Lead Local Flood Authority
Post Point CHN 215
Hertfordshire County Council
County Hall, Pegs Lane
HERTFORD SG13 8DN

Date 17 January 2018

RE: 6/2017/2964/MAJ – Blue Moon Paddock Woodfield Lane Brookmans Park AL9 6JJ

We have reviewed the Flood Risk Assessment (focus on surface water management) dated 30 June 2015 submitted to support to this application.

**Drawing No.**  
**P/502/A**

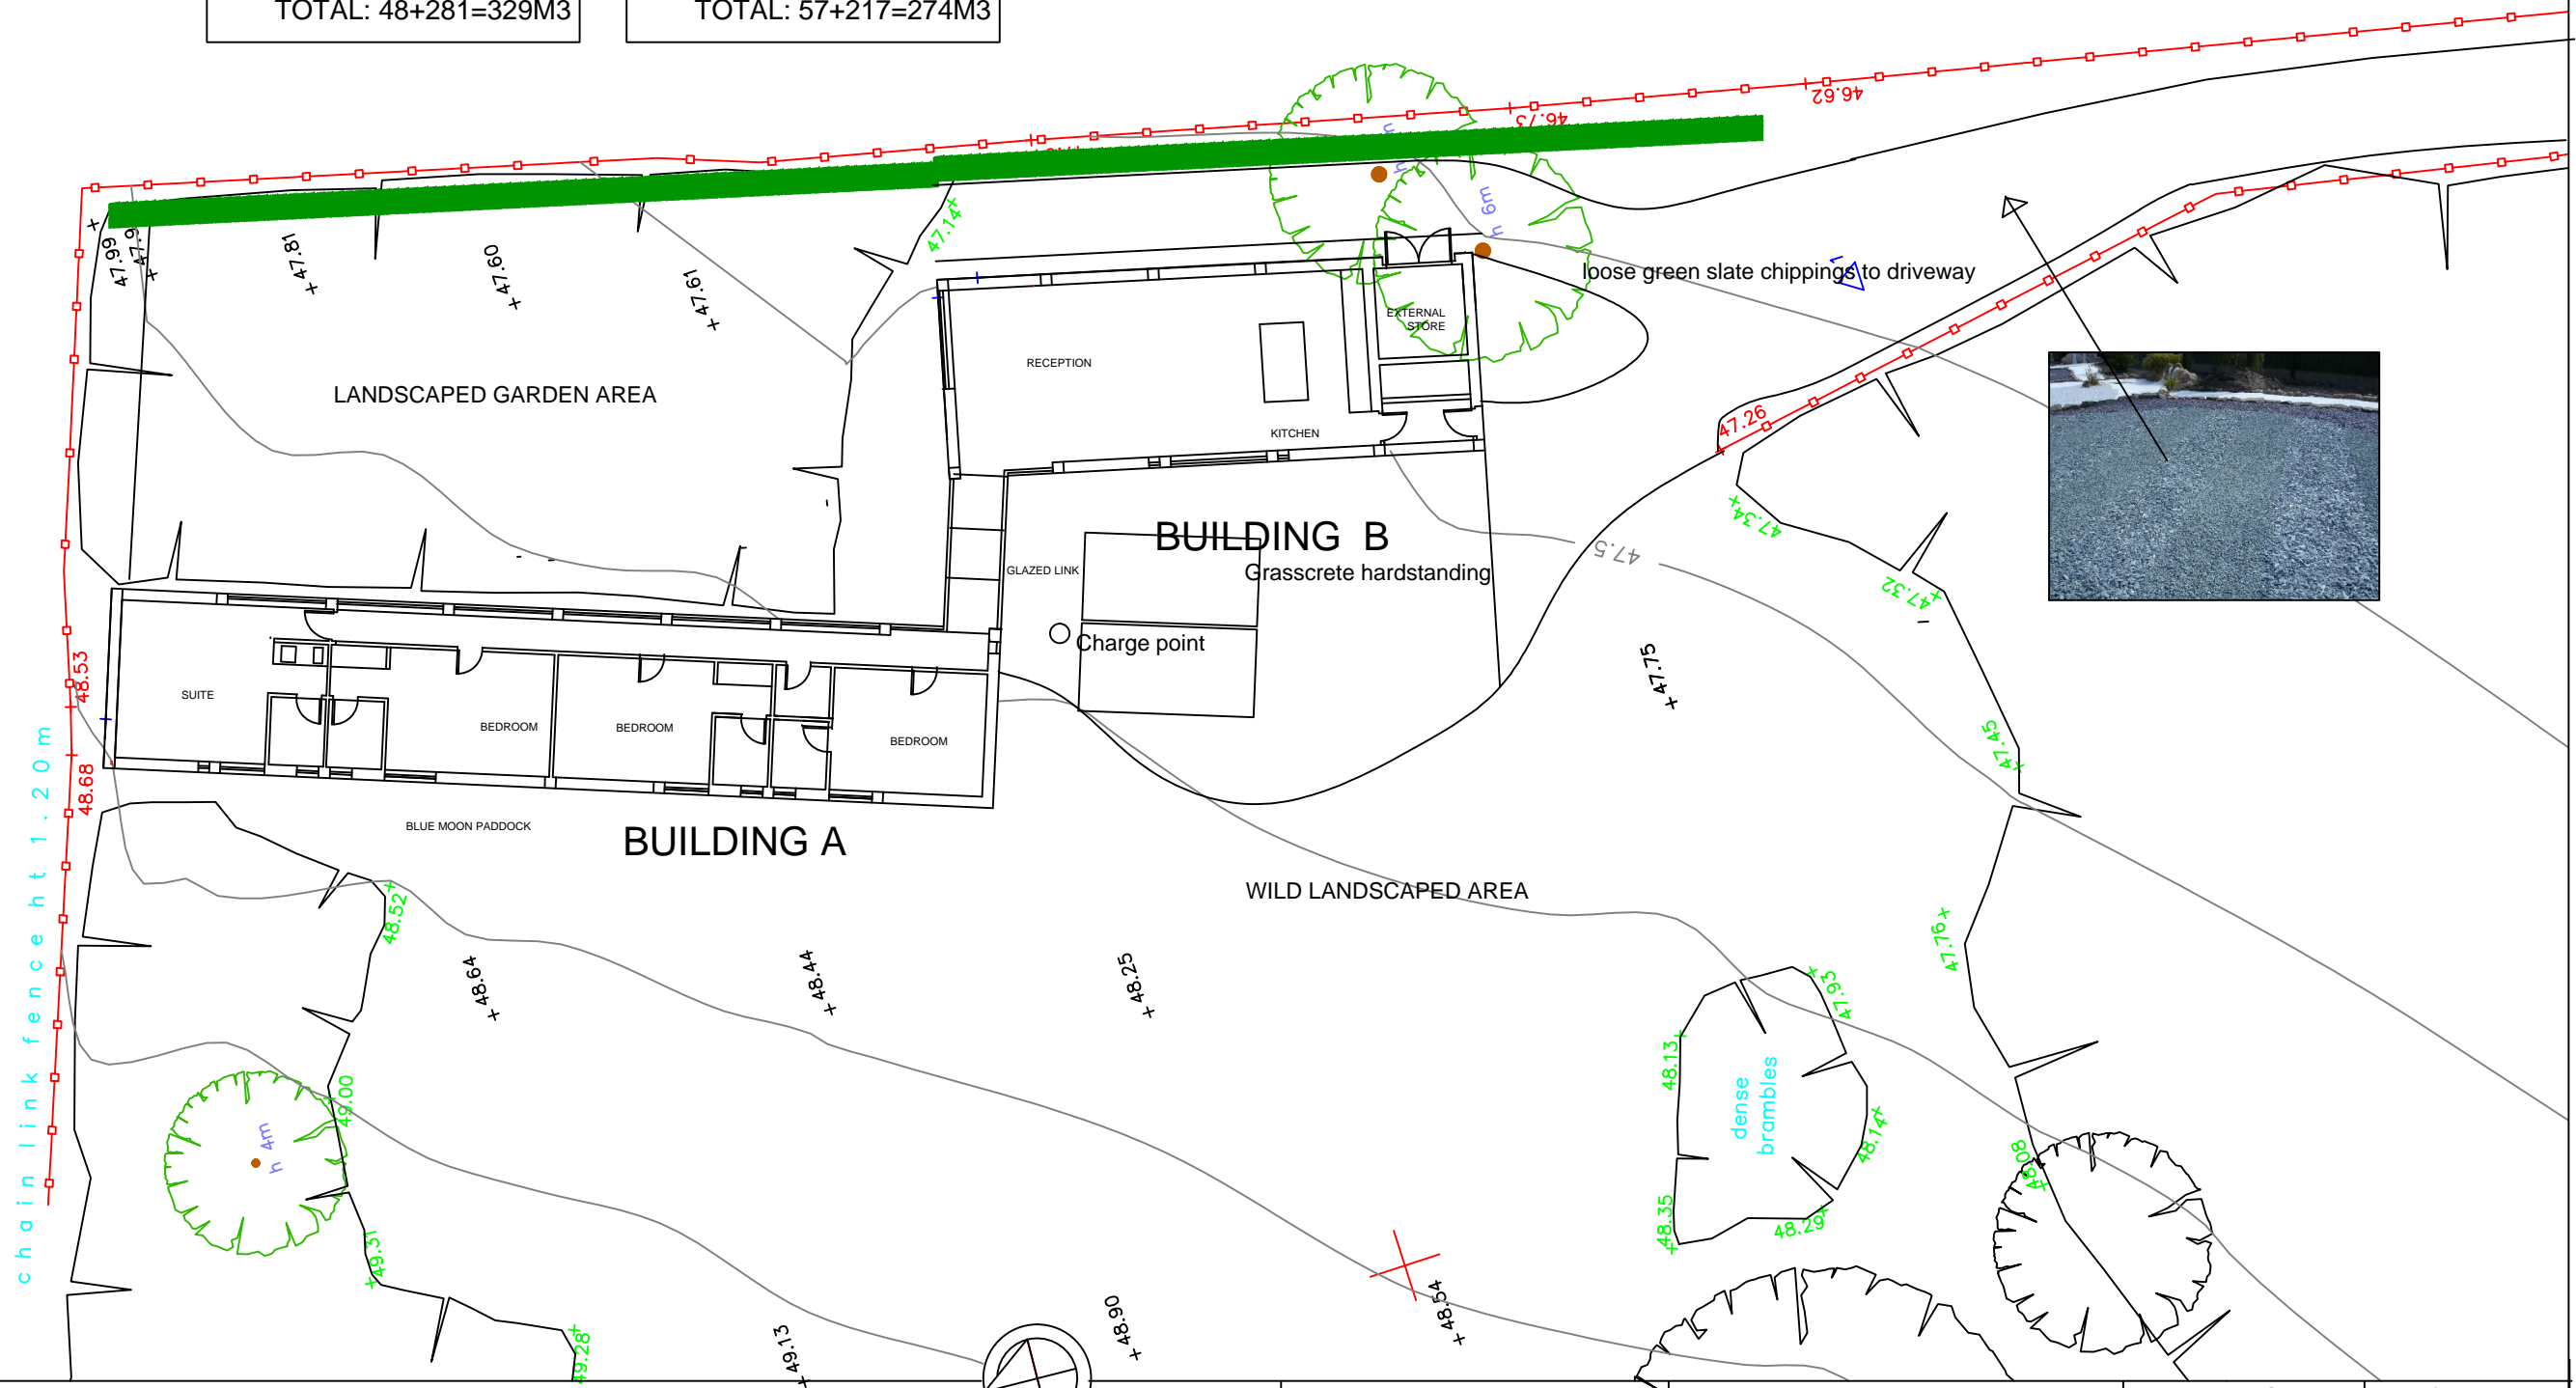
4. Clarification and provision of information in relation to the proposed car parking area.

order to include details regarding the parking area, including area and location. This area should also be included in the proposed site plan.

**Drawing No.**  
**P/502**

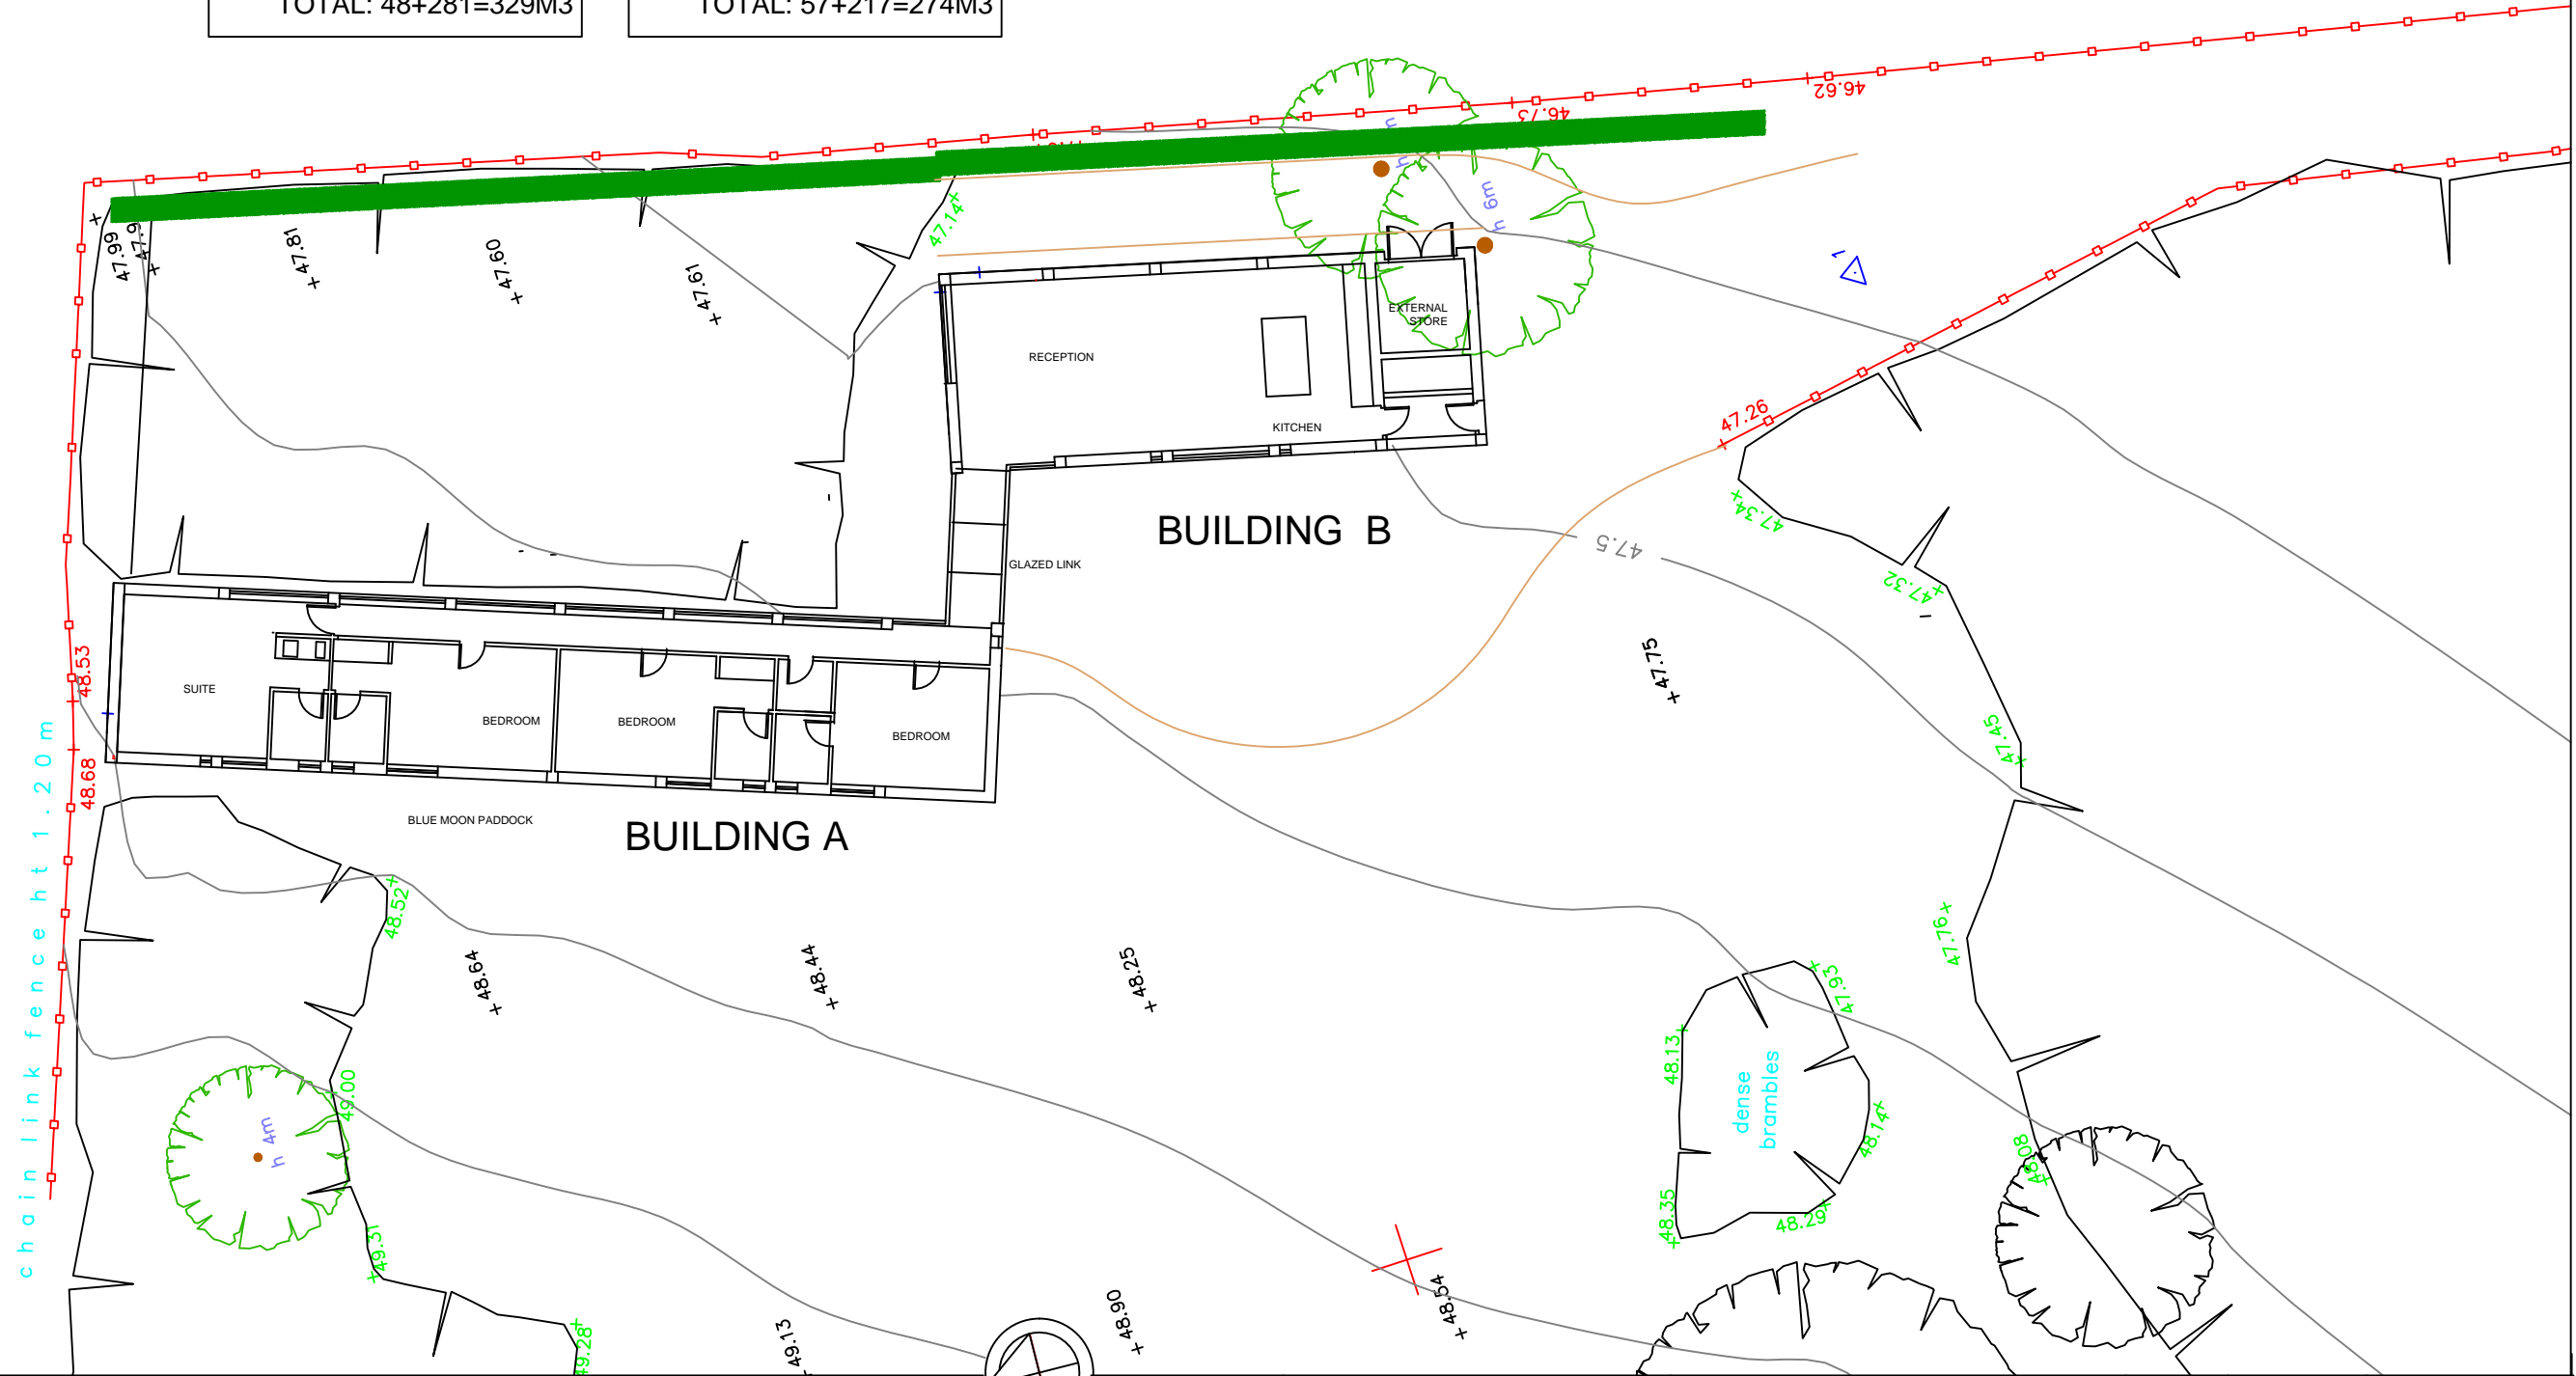
3. The applicant is proposing to drain the surface water runoff into an above ground feature. However no information have been provided regarding the location of this attenuation feature. Also the drawing No. P/502 – Proposed site plan submitted in support of this application do not show the above mentioned feature. Hence we require clarification regarding the proposed drainage scheme and the provision of a drainage scheme showing the location of the attenuation of the proposed SuDS feature, pipe runs, discharge points and informal flooding (no flooding to occur below and including the 1 in 30 year rainfall return period) along with all the corresponding detailed calculations.
4. The planning application refers to a car parking area however no information is provided regarding this area. The drainage strategy should therefore be updated in
